Application no: H06/0249/02

Description: New double garage

Location: Kitling House
Stonegate
Gedney

TOWN AND COUNTRY PLANNING ACT 1990
NOTICE OF ACCEPTANCE OF AMENDMENT

338-02 A

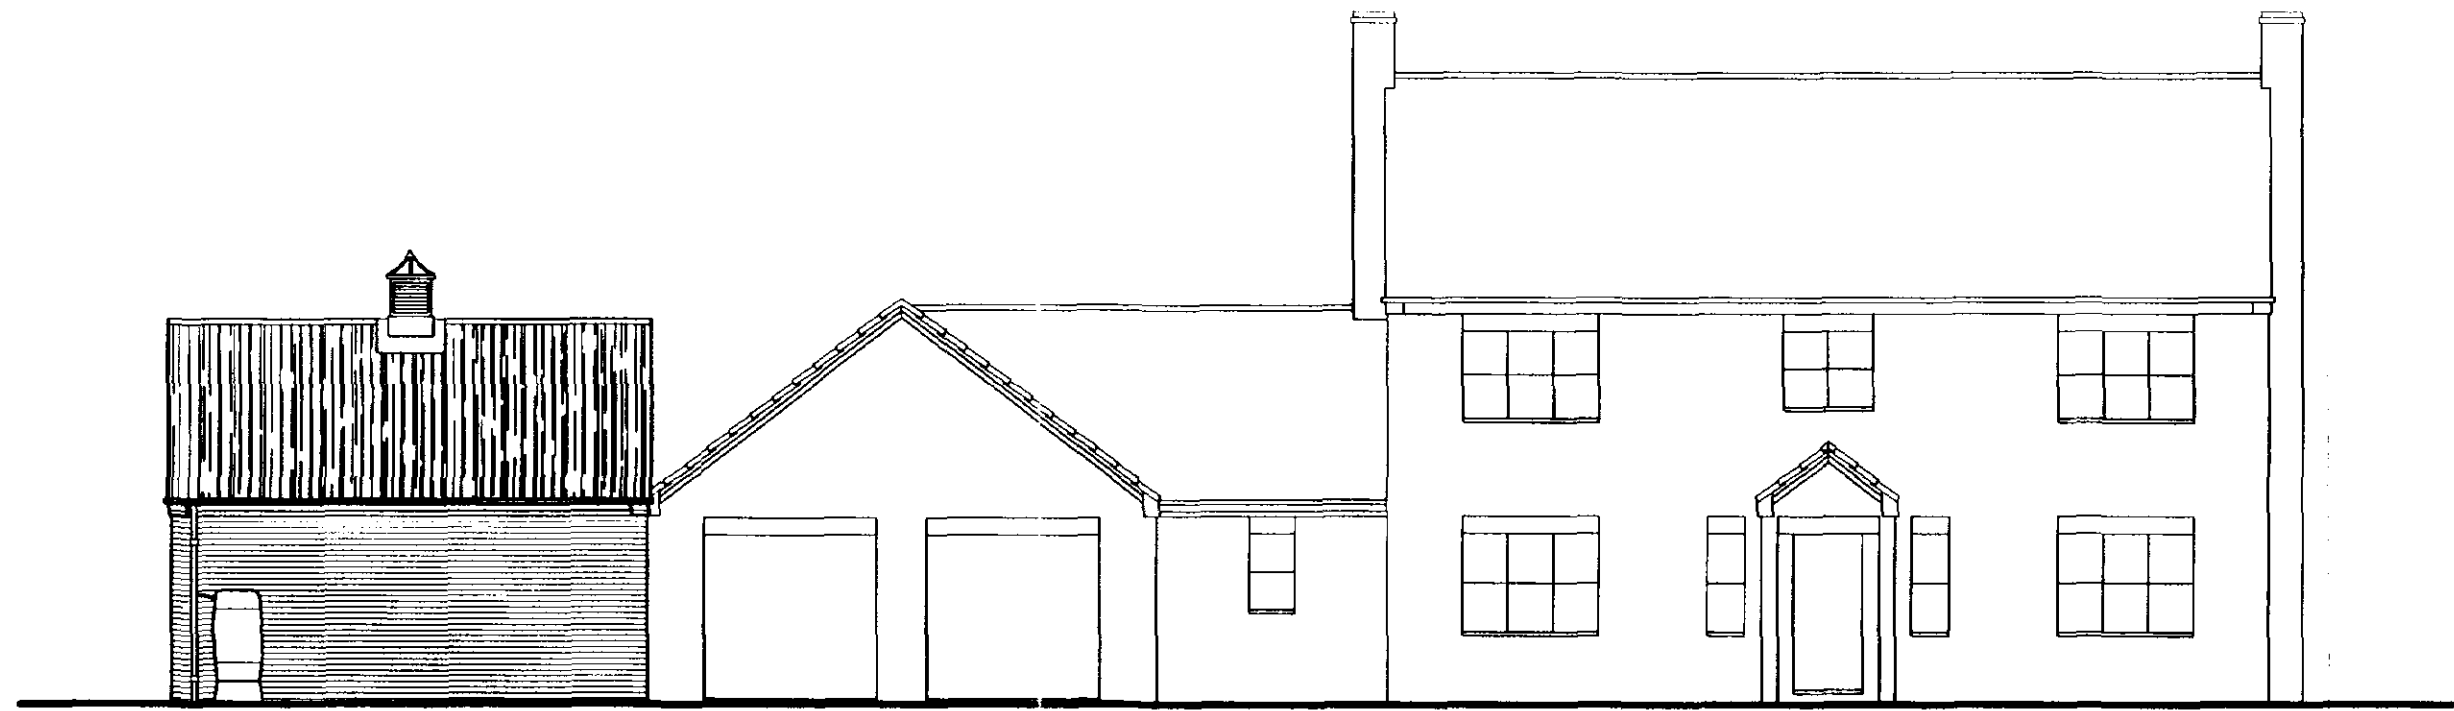
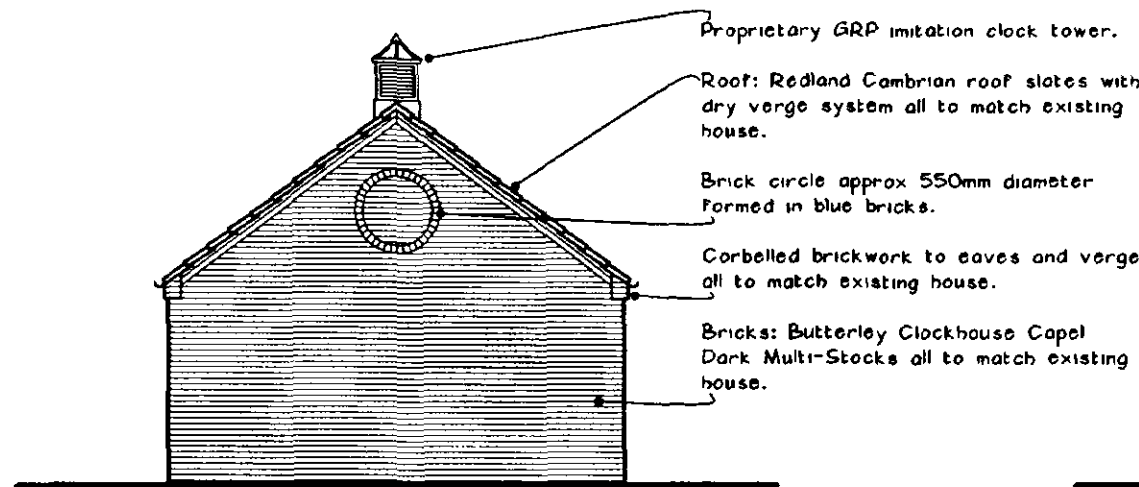
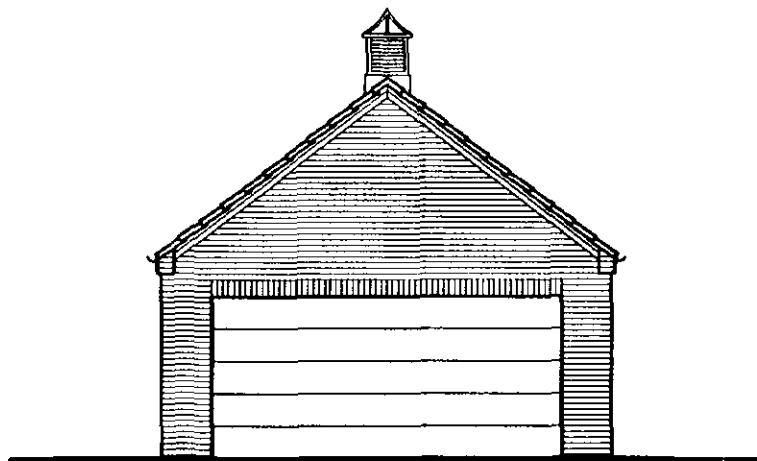
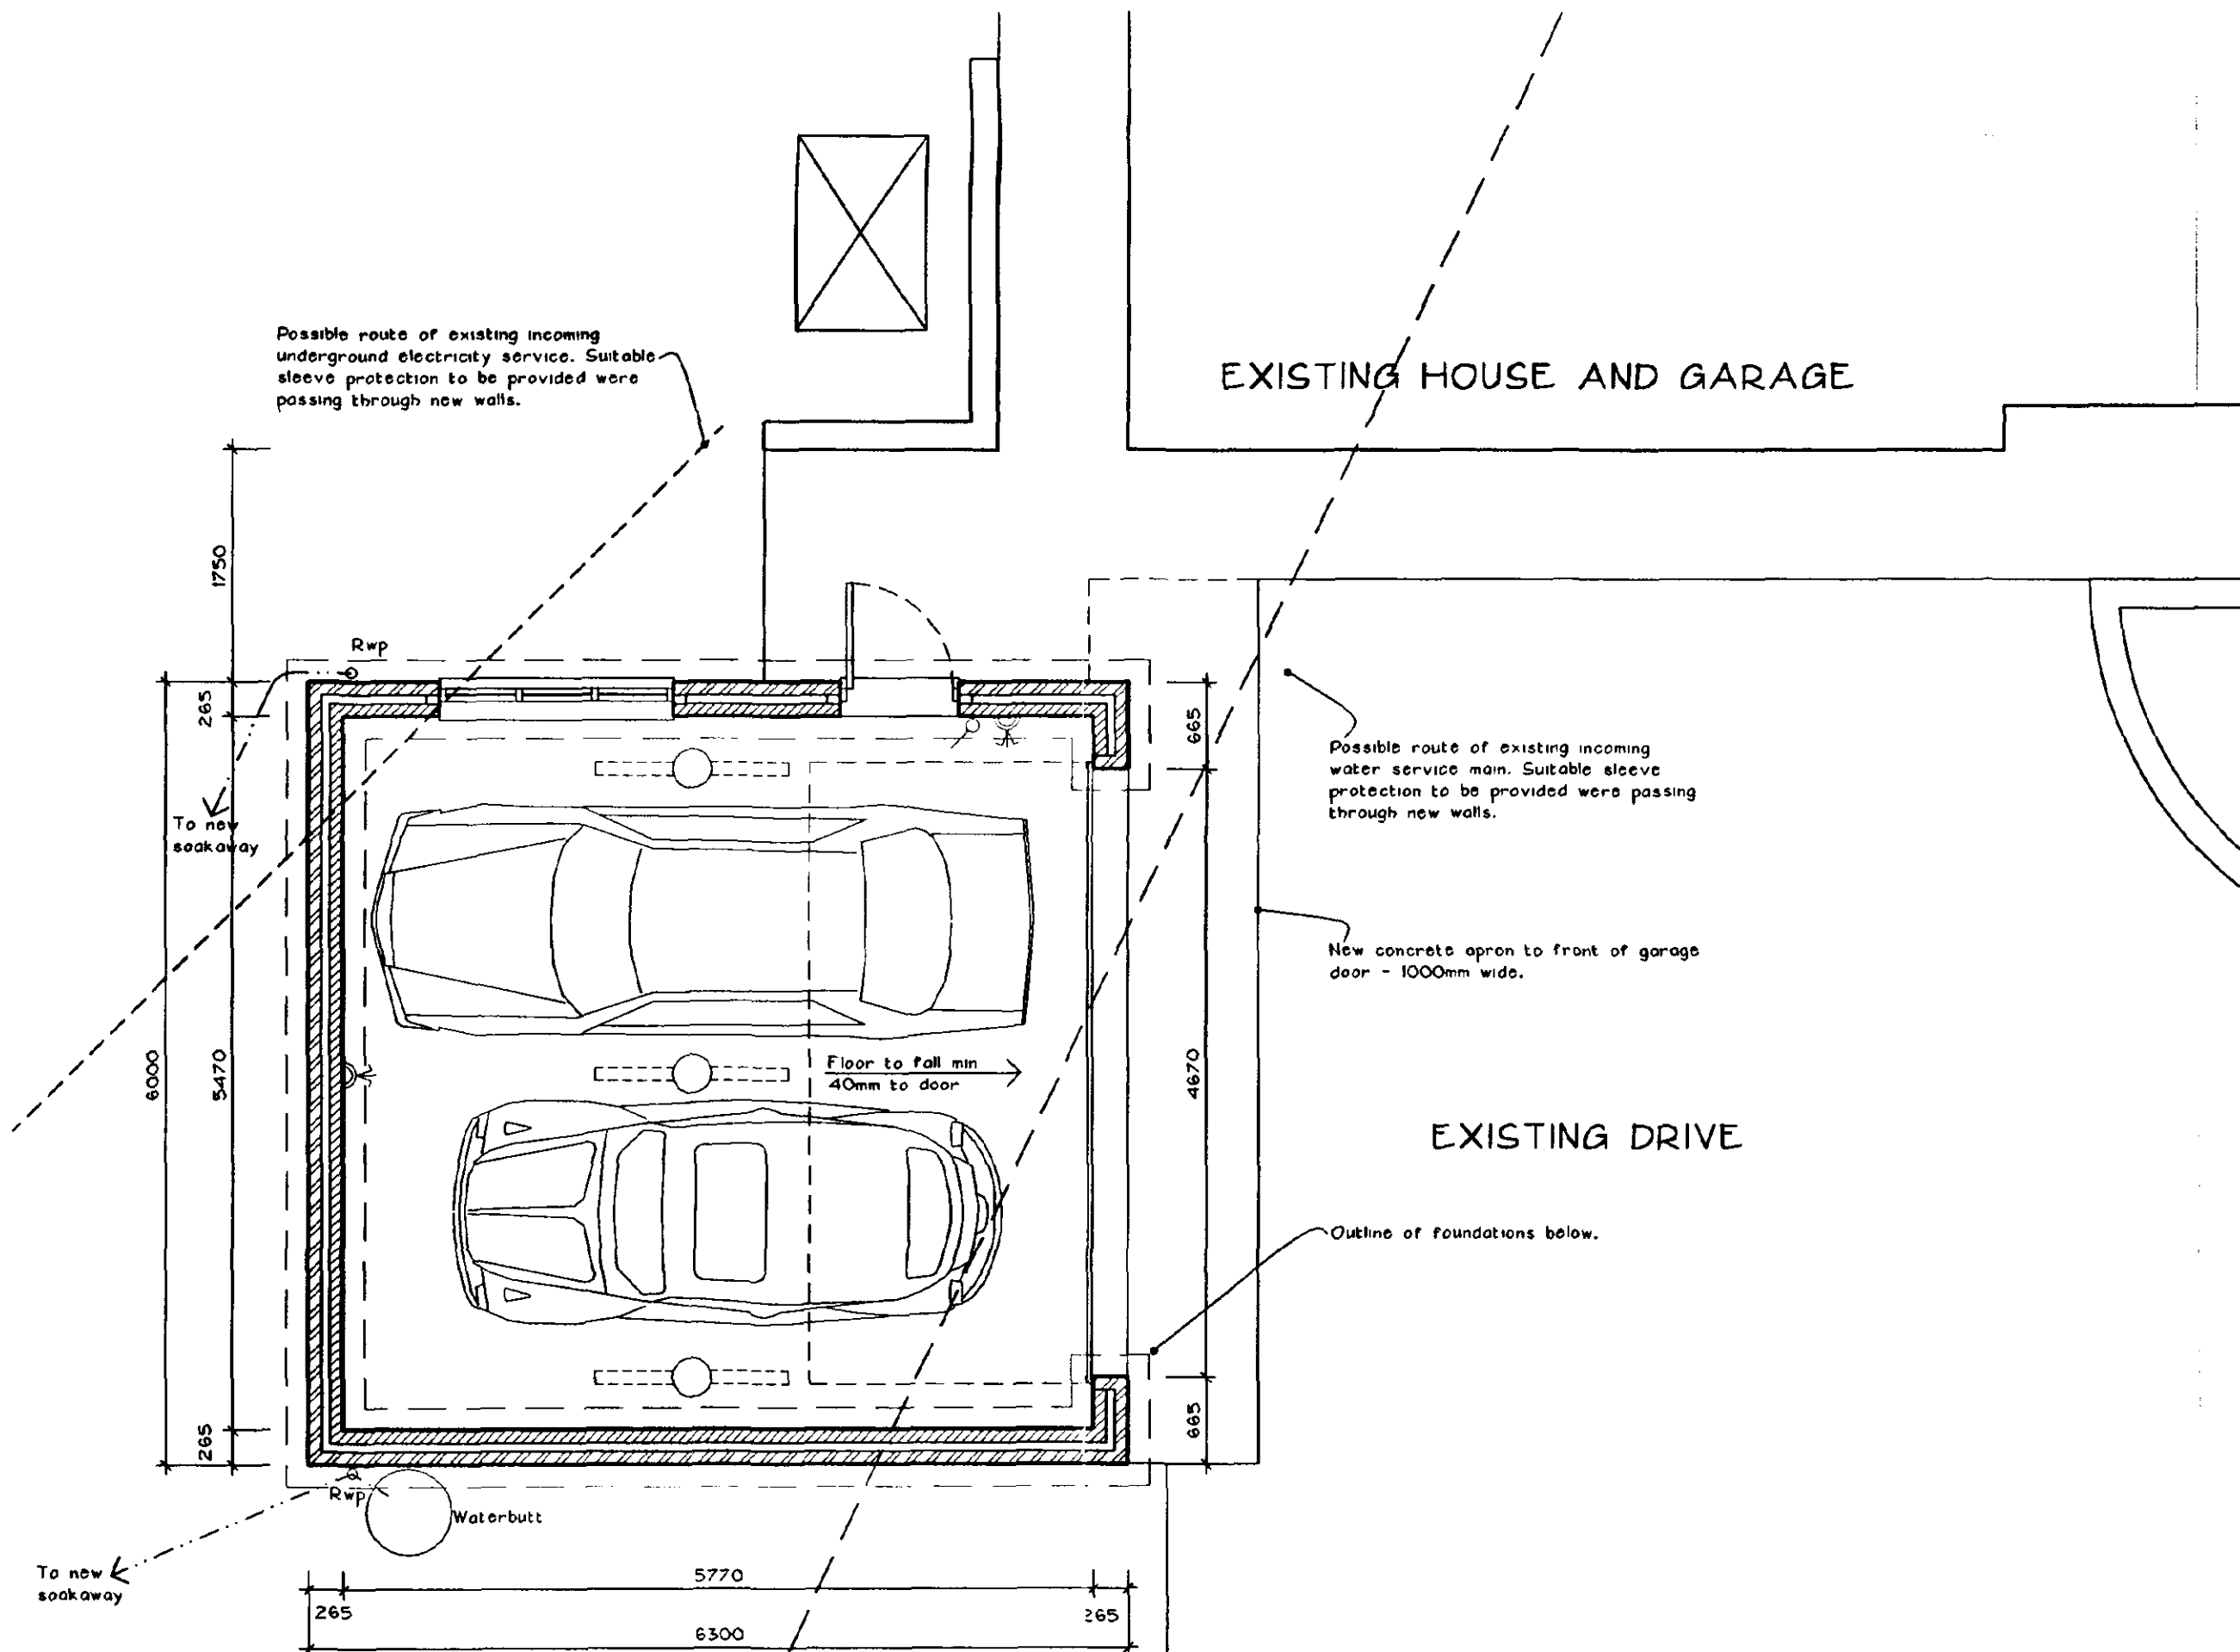
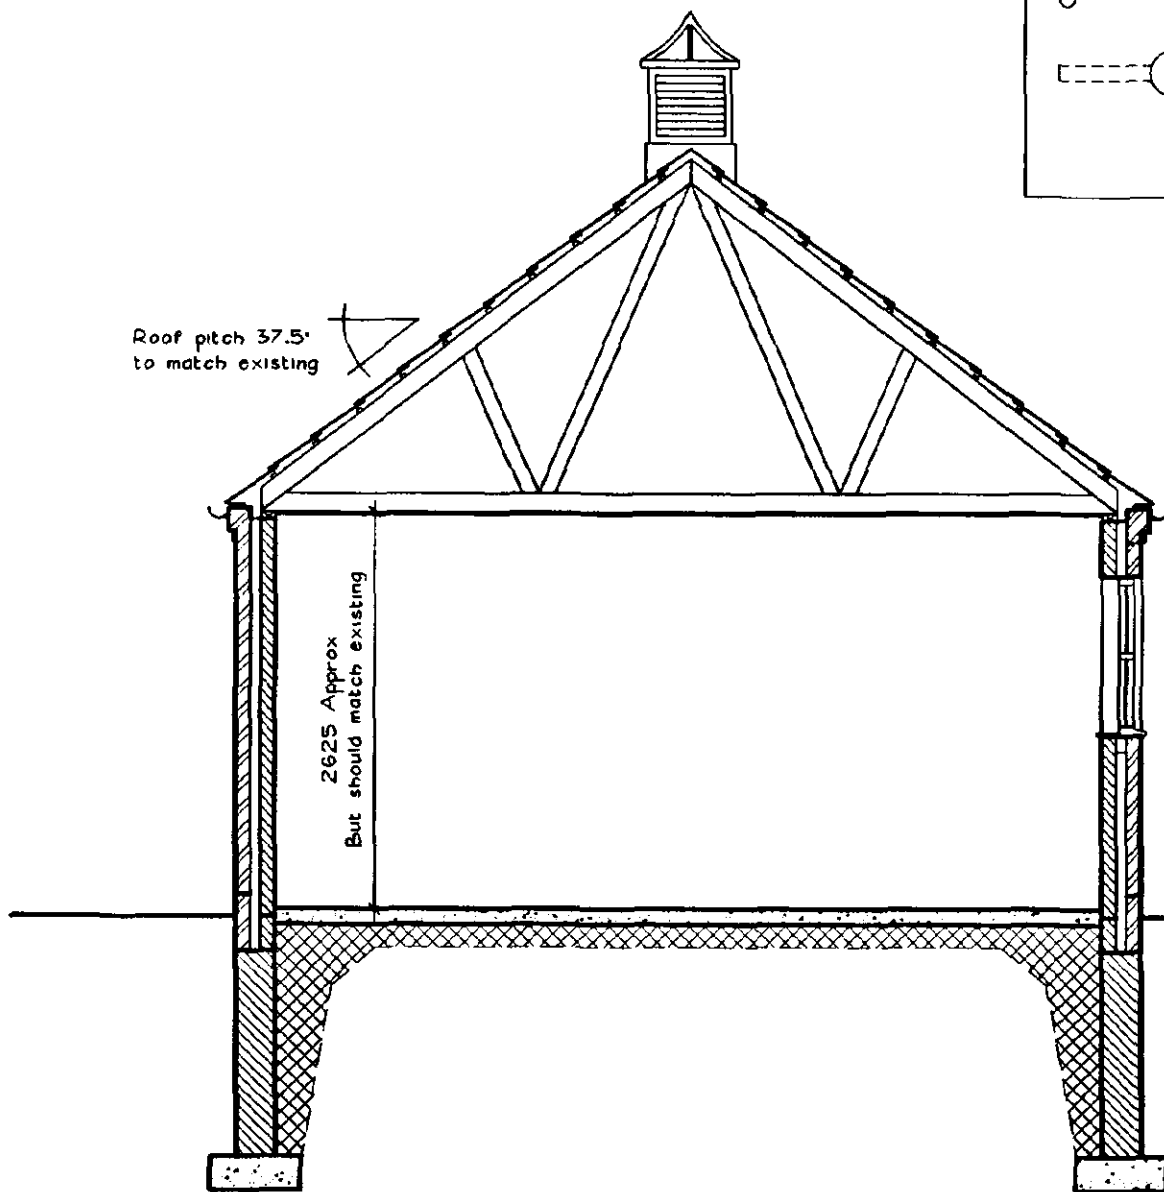
Amendment: Garage increased in length to bring in line with existing building. (Dwg nos. 338-01-B & 338-02A)

GARAGE INCREASED IN
LENGTH BY 300MM
BRINGING FLOOT IN LINE
WITH SIDE OF EXISTING
BUILDING.
